From:
Sent: 24 February 2024 12:42
To: DCAdmin
Subject: comment on planning application - 2023/93576

CHANGE OF VIEW

Appendix 3: Proposed Development Plan

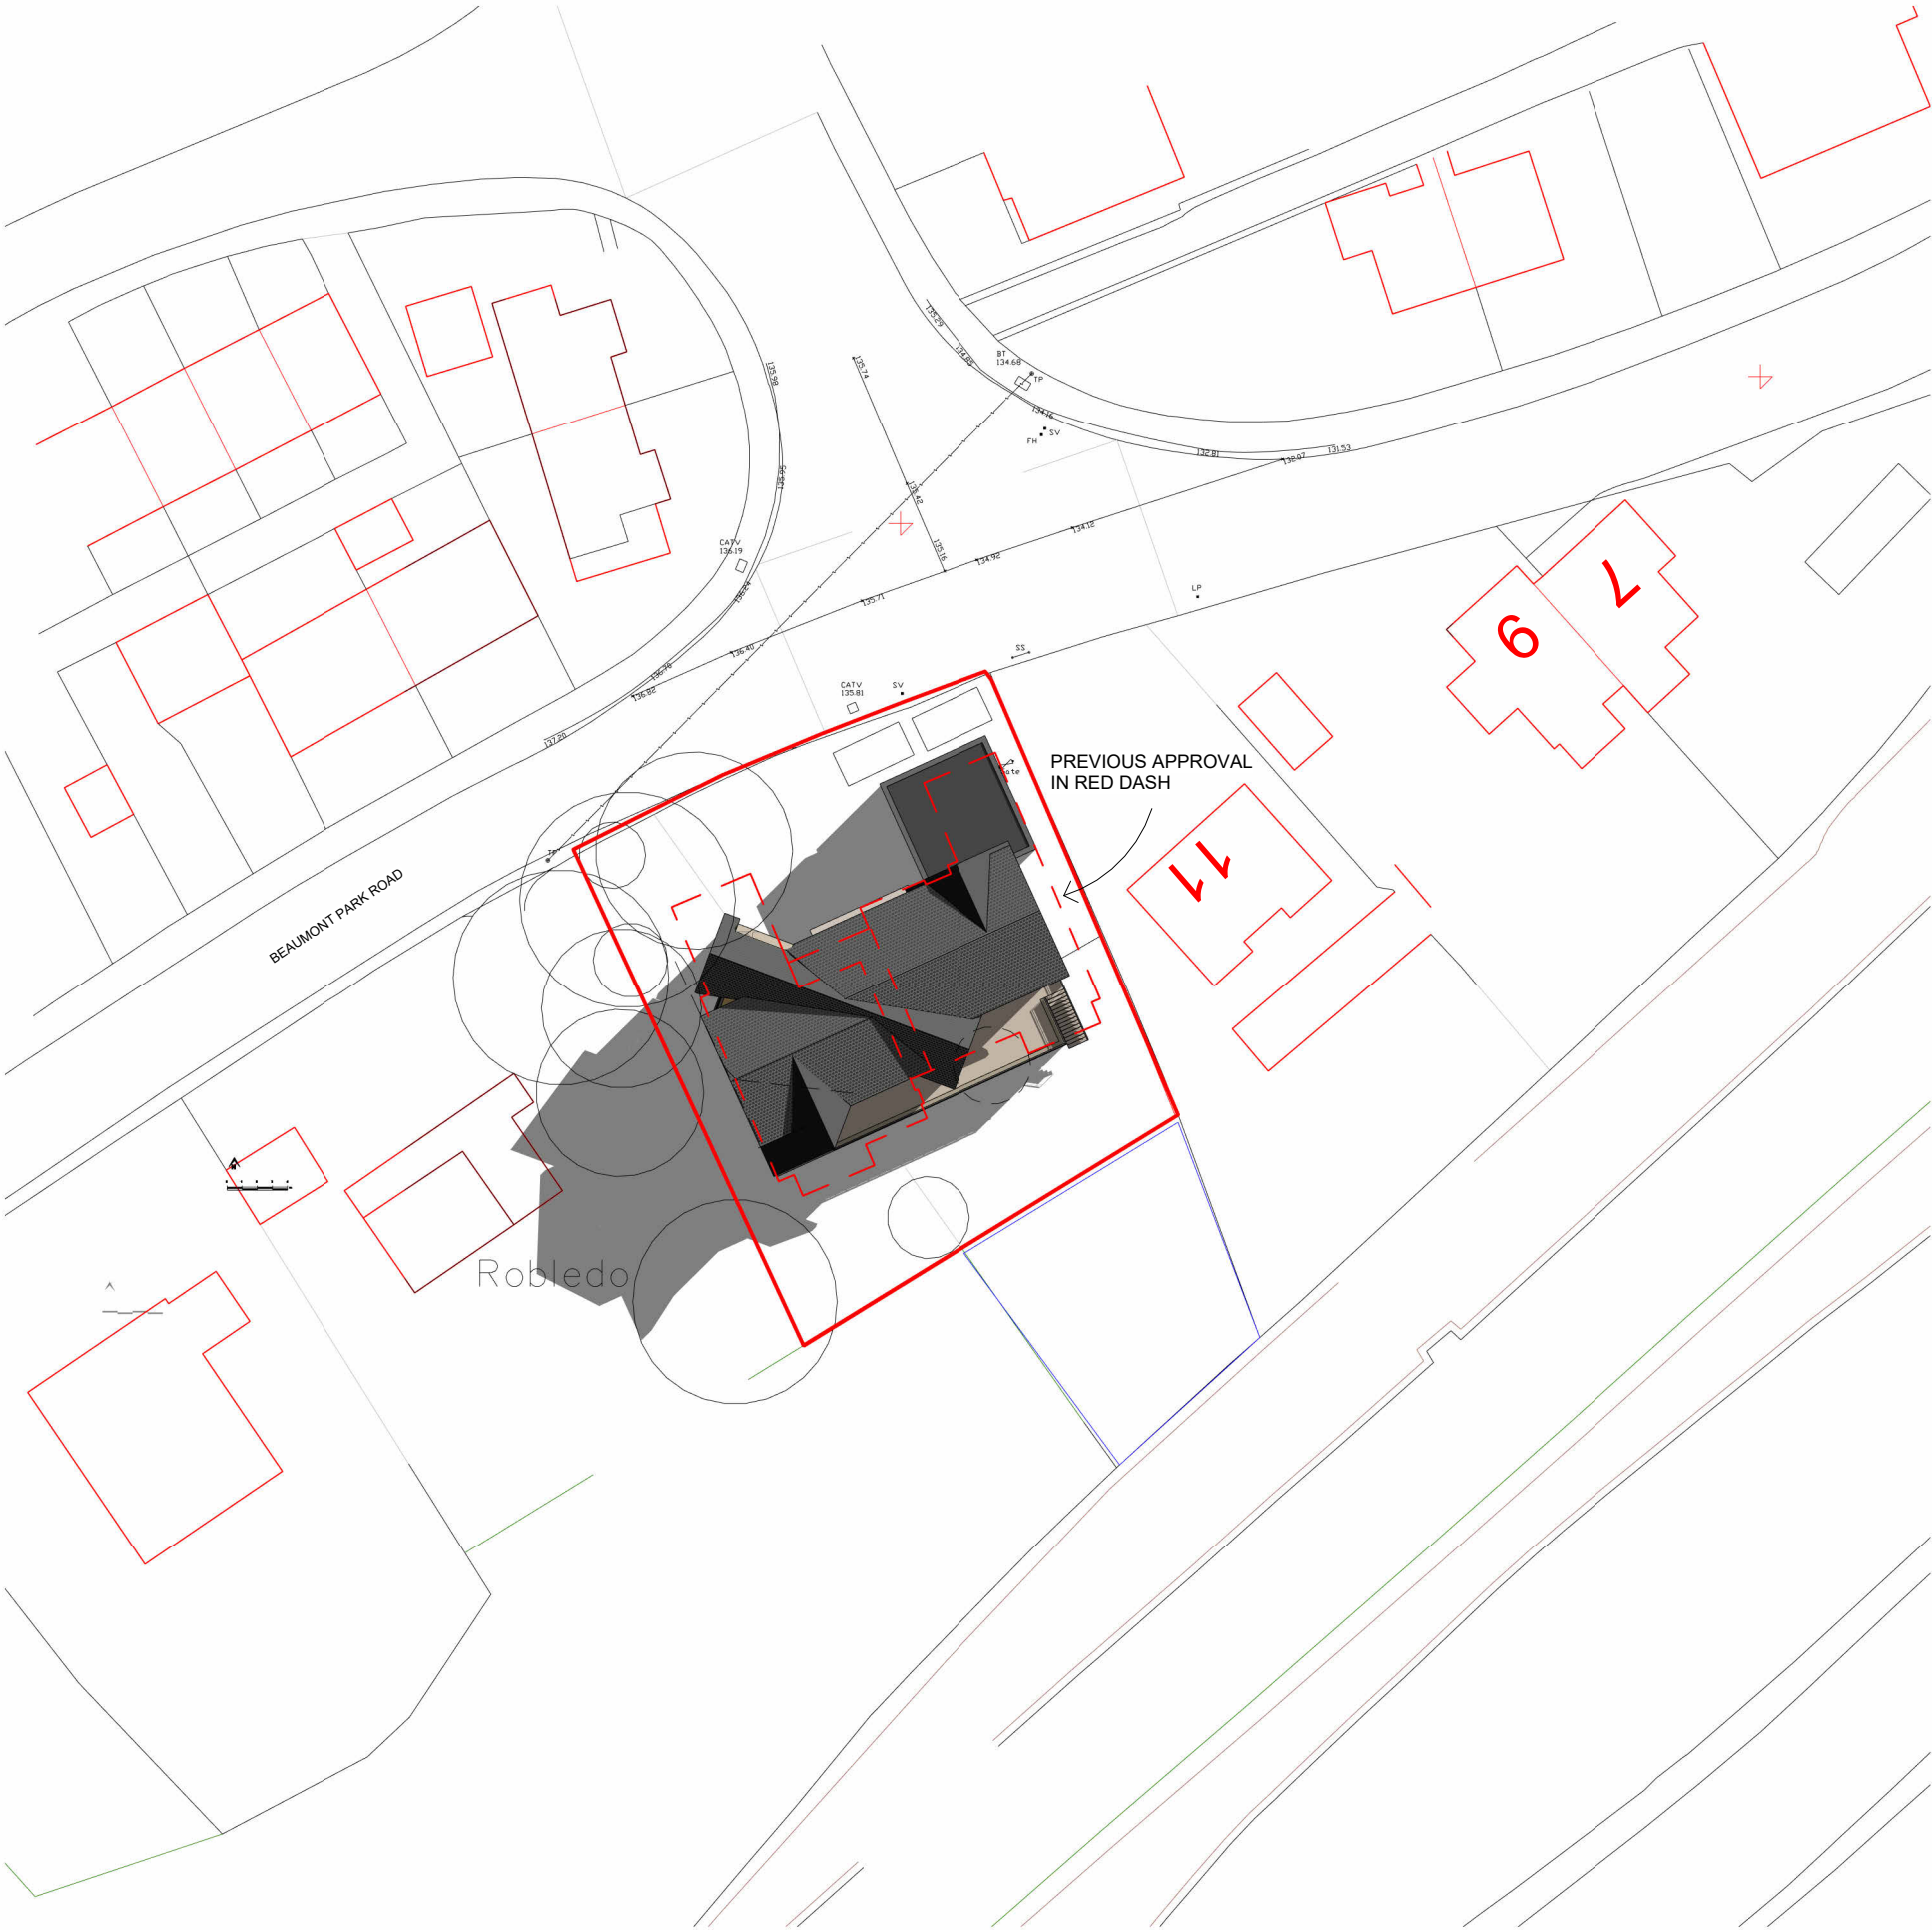
Here I have acquired images of a toilet block (below writing), this to me looks like the garage that is going to be built. Suggestion for the building, change the window placement to something more visually pleasing rather than a box with small windows looking like its got toilets inside. We are losing quite a bit of our view and something more pleasing to look at would be appreciated.

We hope there is sufficient parking in the garage and drive because there will be nowhere to park on the road as it is a junction.
